Our Ref: 2023/455039
File No: R/2017/25/N
Your Ref: SSD-8925-Mod-11

New Sydney Fish Markets – SSD 8925 Mod 11 – Advice on Modification

The modification relates to a proposed change of the approved road levels of Bridge Road involving the reduction of height of Bridge Road by a metre (to a level similar to its existing level), and as a result amendments to the height of bus/taxi bays, and landscaping across the Bridge Road frontage of the Sydney Fish Markets.

Figure 3 Outline of the Bus Bay (orange) and Taxi and Ride services bay (green)

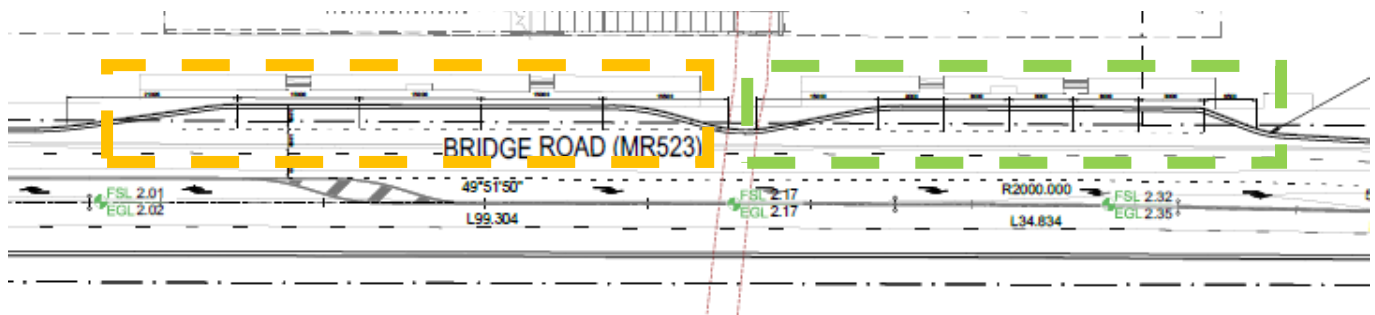
The existing approved design provides a single 130m indented bay to be shared by coaches and taxi/uber. The proposed modification is seeking to amend this to two bays for coaches and taxi/uber that are 45m and 40m long respectively.

Separating out coaches and taxi/under is supported by the City. It will provide clearer direction to people driving and is a safer outcome for drivers.

The total length of layby has decreased from 130m to 85m which represents a drop in capacity, however the Traffic Impact Statement notes that the approved 130m was well in excess of the predicted requirements, which can still be fitted comfortably within the shorter laybys. The City is supportive of this modification.

The modified footpath design now proposes the lower footpath next to the drop off bays at only 1.8m wide. This is very narrow and would feel cramped and potentially dangerous, particularly for people using mobility devices or prams. People will also be using the space to wait for coaches, making it even more crowded.

Considering the Traffic Impact Study estimates around 540 people per hour using coaches, 1.8m would score 'F' on the Walking Space Guide which would require at least 3.9m to meet Level of Service score 'C'. The City recommends the footpath design be widened to achieve a Level of Service score of 'D'.

Figure 7 Illustrative section indicating landscaping zones between amended Bridge Road and building

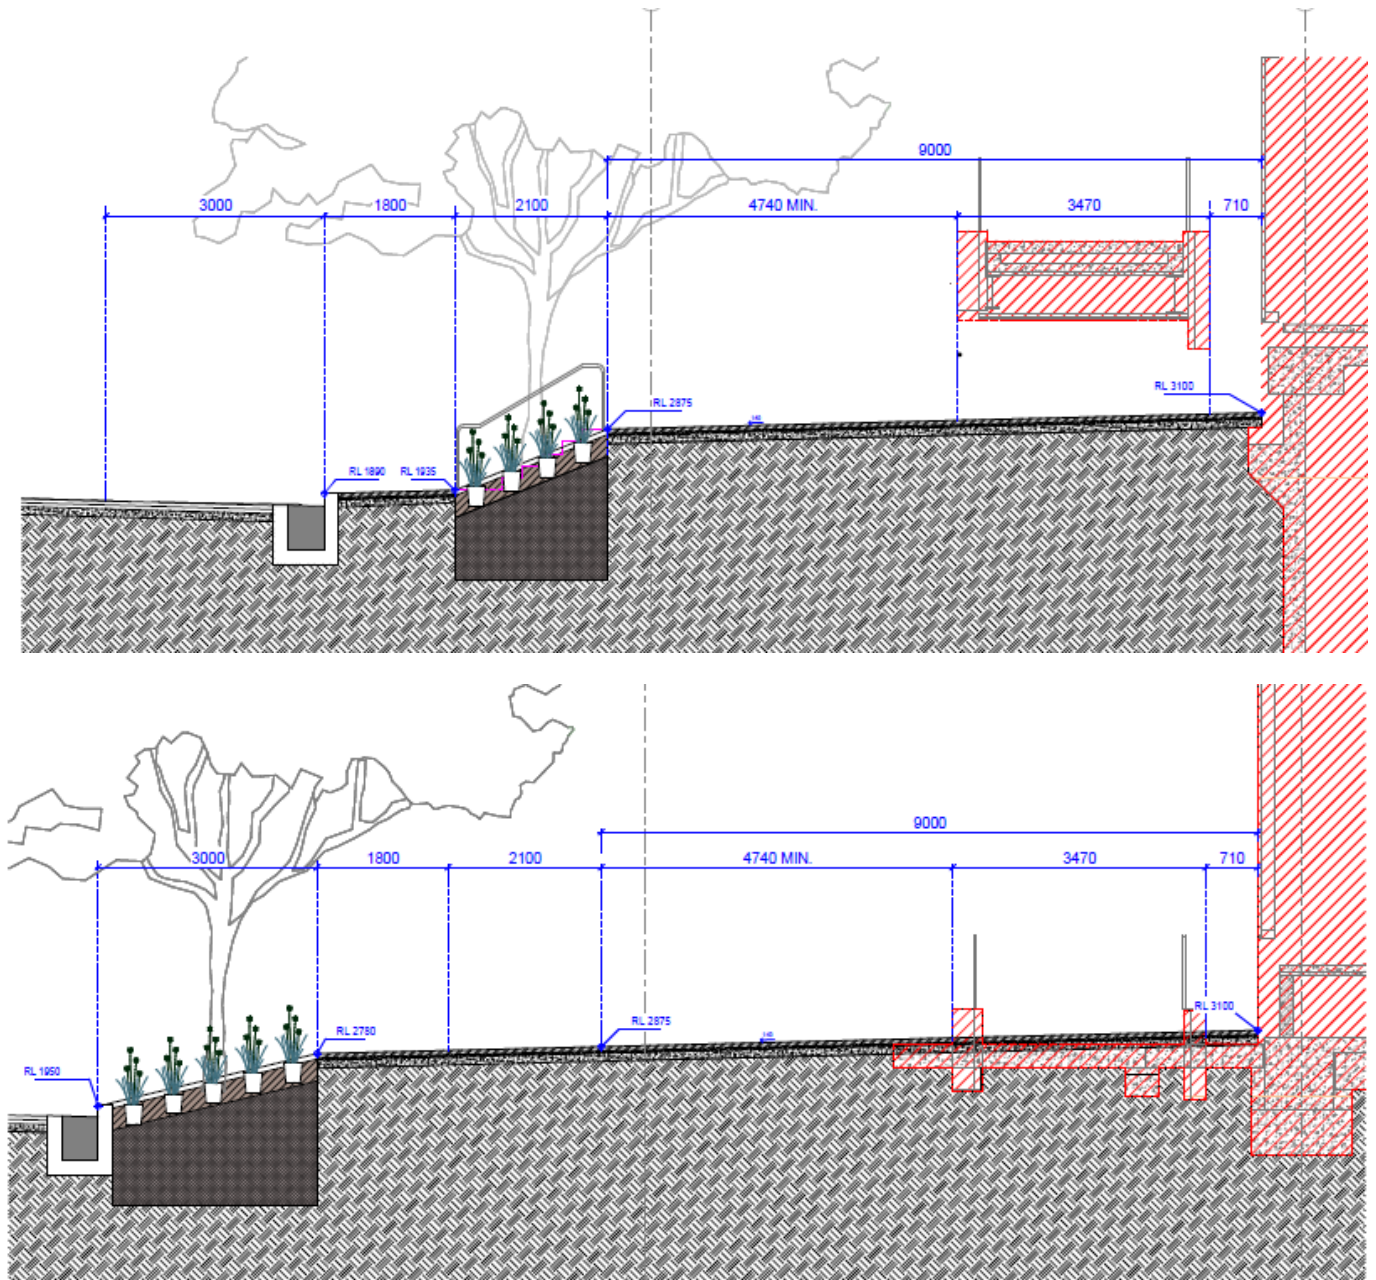
Concern is raised however, that future modifications may seek to reduce the landscaping and footway widths being proposed along Bridge Road. The following minimums should be conditioned in any modified consent to preserve the proposed landscape treatments:

- 1800mm for kerbside footway
- 2100mm for planted verge

AMENDED BRIDGE ROAD DESIGN
PLAN OVERLAY

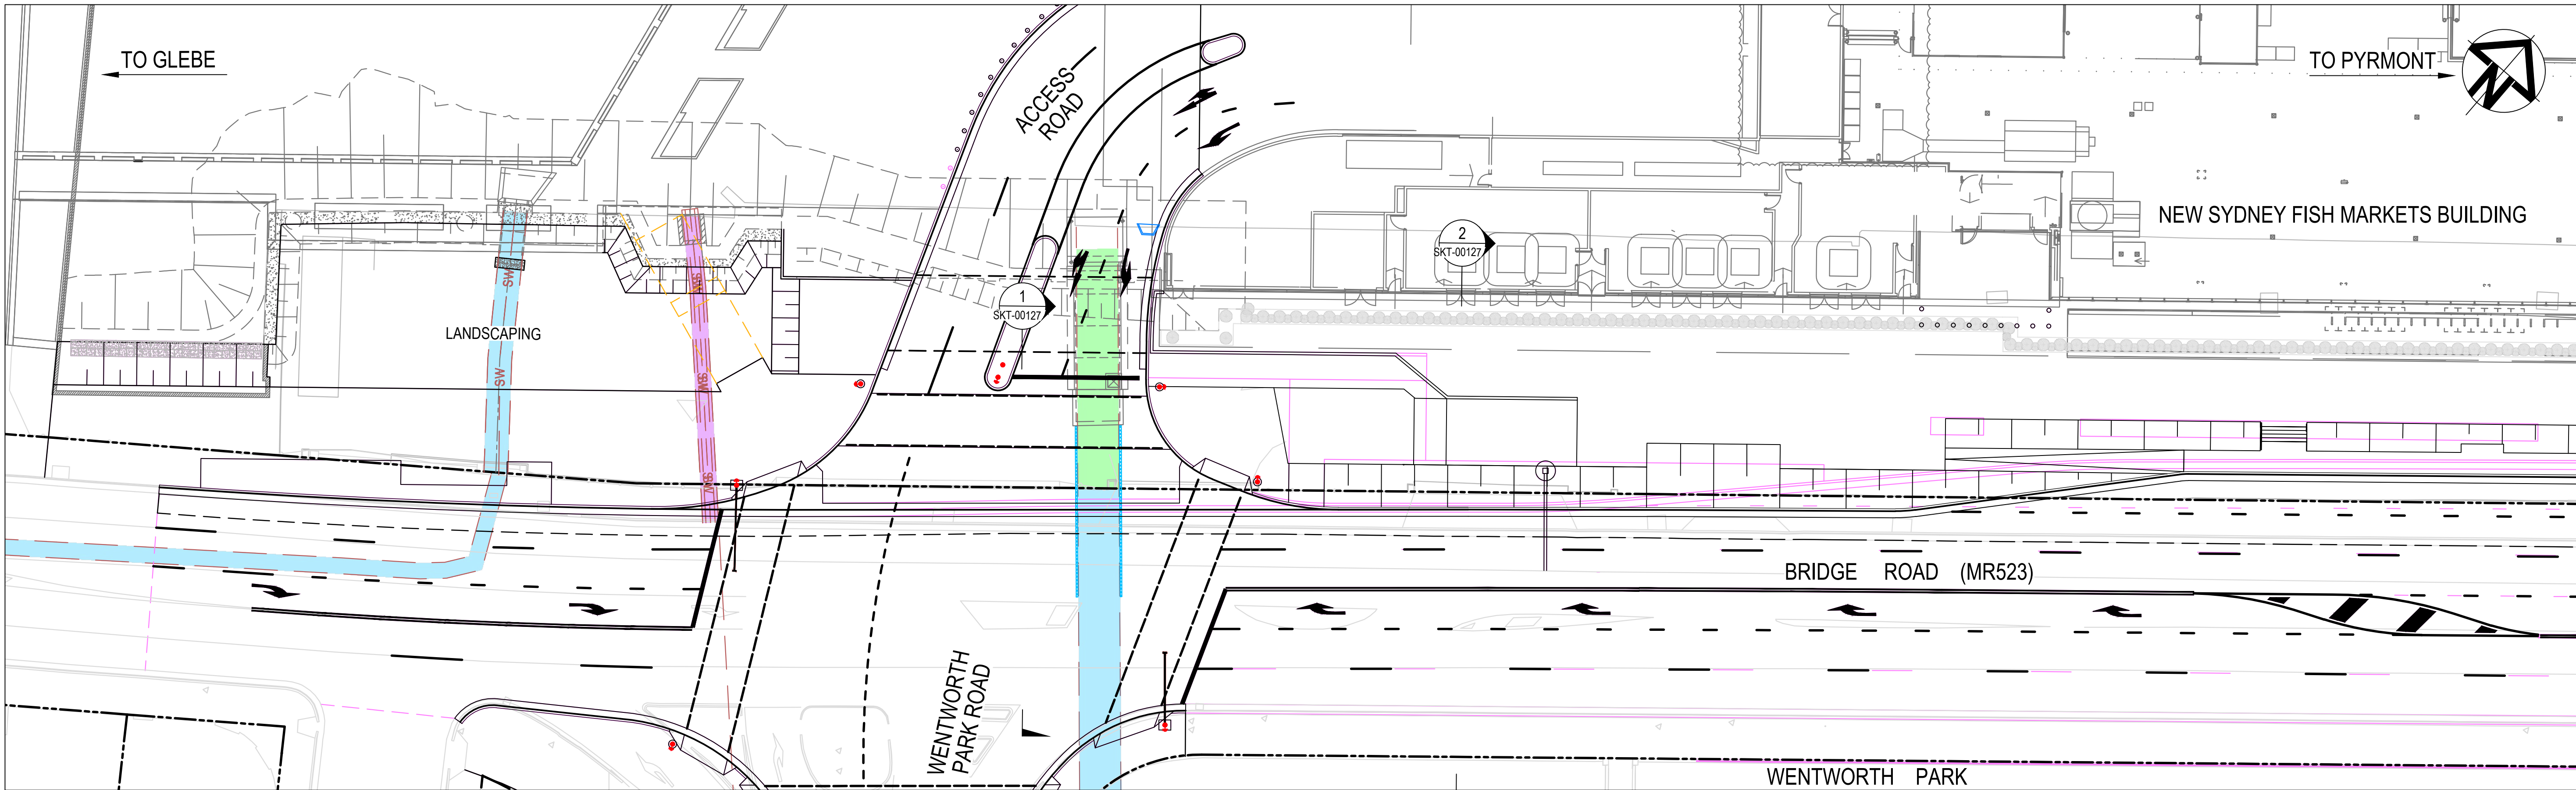
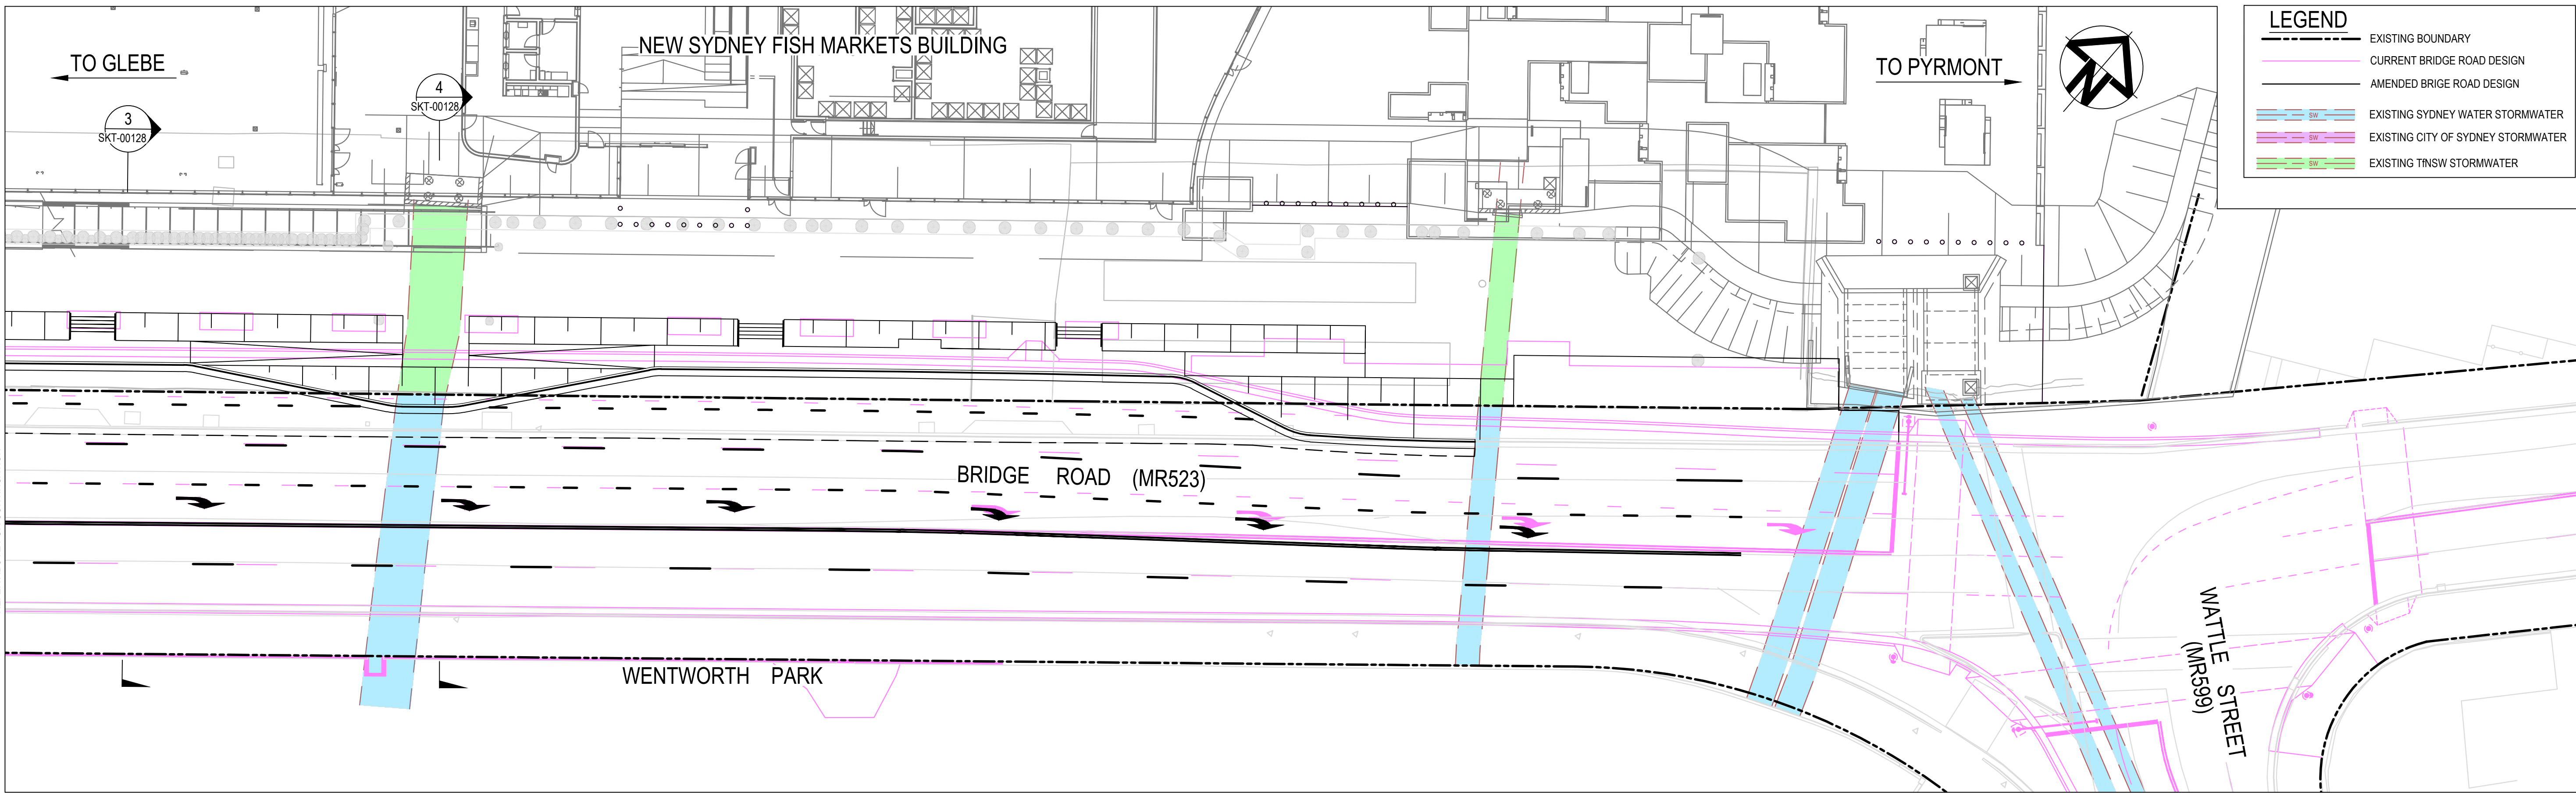
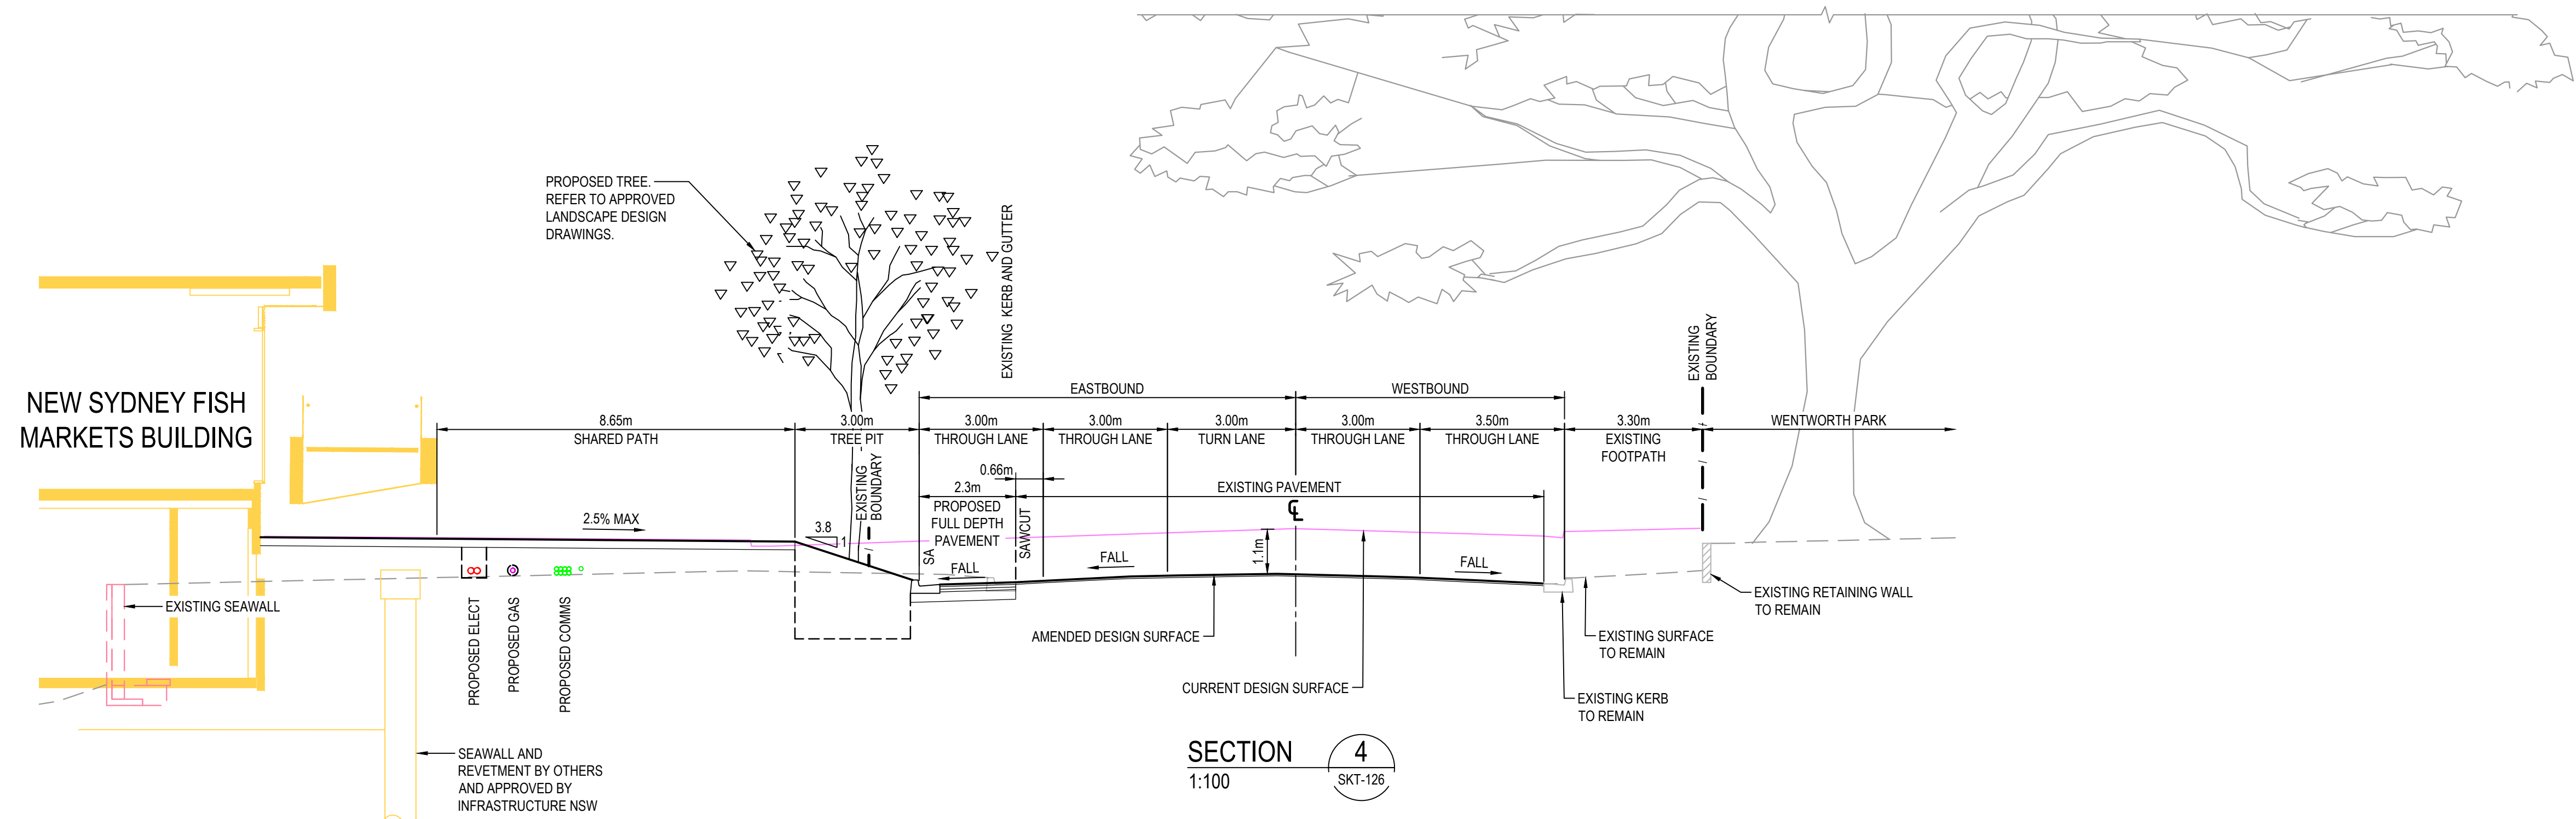
The existing intersection includes a slip lane from Wattle Street onto Bridge Road. The existing approved design removes the slip lane and was supported by the City. The proposed modification is now seeking to revoke this and leave the intersection unchanged from its existing state, an outcome that the City does not support.

Slip lanes create poor outcomes for people walking. Slip lanes generally allow traffic to turn at high speeds, prioritising vehicle speed over the safety. They also increase the distance people must walk to cross the road. In the modified design, crossing Wattle Street would be a two-stage crossing rather than a single stage, again prioritising cars over walking.

The submitted Traffic Impact Study makes no justification for the change, other than saying that it would have "no detriment to the road network in the vicinity of the development". That is, there are no benefits to including the slip lane for people driving, and only negative impacts on people walking or cycling.

Including the slip lane would also make it more difficult to get a northern leg on the intersection, which is needed for access to the Blackwattle Bay precinct (see Figure 3 [Structure Plan in Blackwattle Bay Design Guidelines](#)).

Overall, the City does not support the reinstatement and retention of the slip lane at this intersection. A new road design should be prepared removing the slip lane and constructing the intersection as per the existing approved plans.
